Addendum No. 1

RE: Contract ID: C202474

4 Sections of US-117 Connector, 1 Section of NC-403 and
1 Section of NC-411

The following revision has been made to the Sketch Maps:

TYPICAL SECTION NO. 4
USE ON MAP NO. 3
 SEE JOINT M.P. TABLE
 FOR APPROXIMATE LOCATIONS

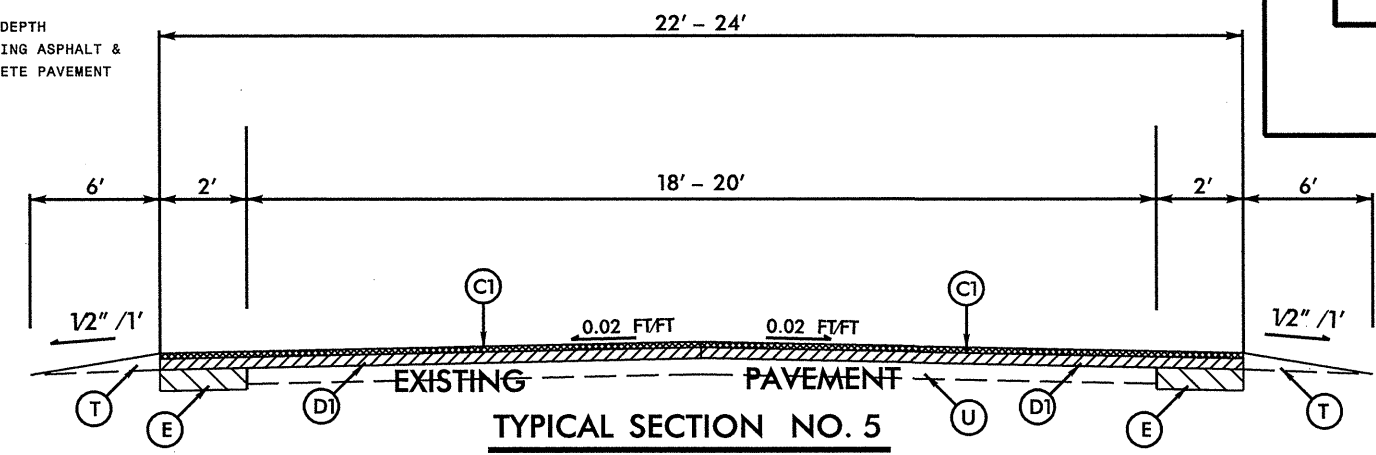
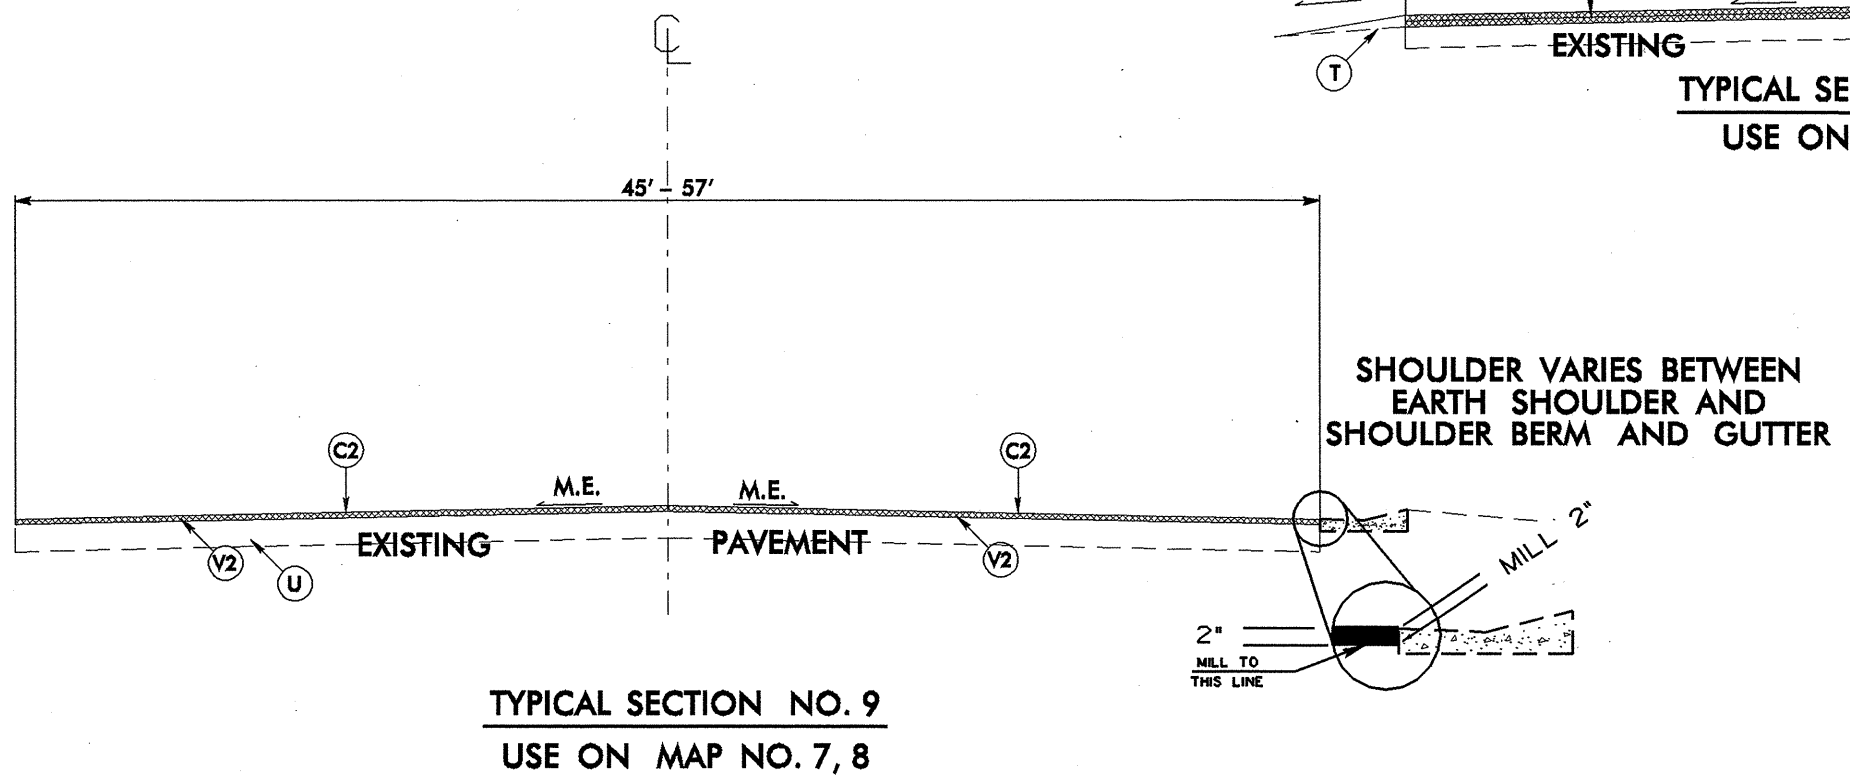
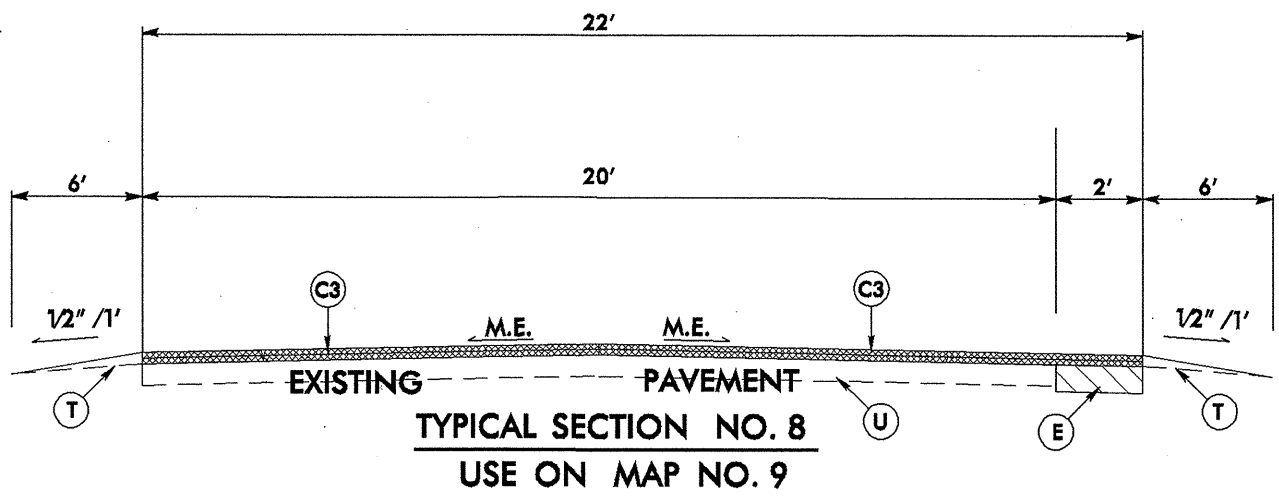
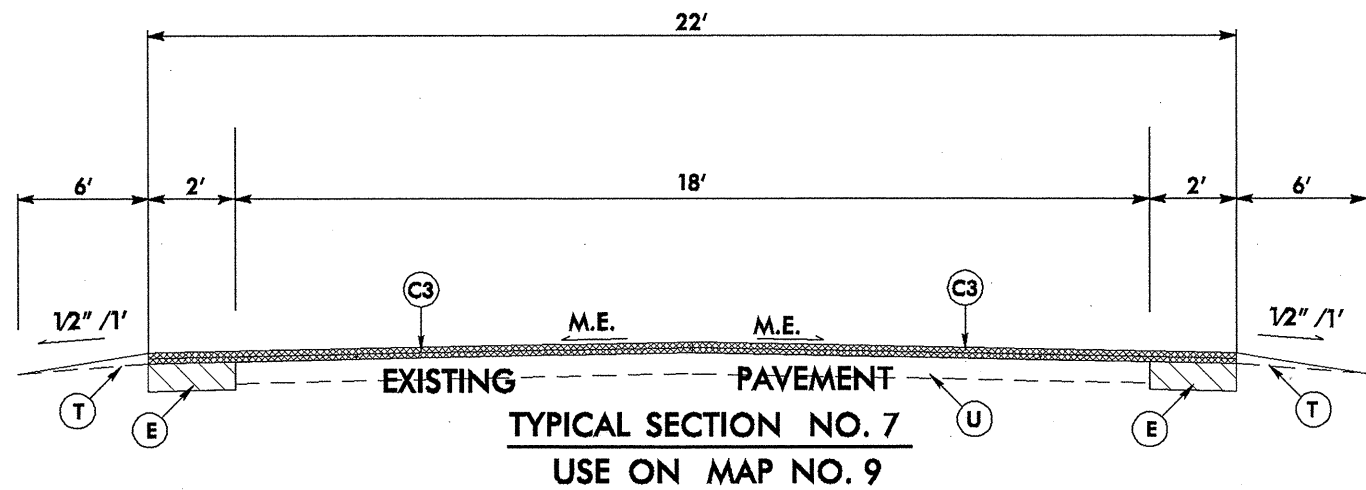
On Sheet No. 4 , Typical Section No. 4 has been revised. Please void Sheet No. 4 in your sketch maps and staple the revised Sheet No. 4 thereto.
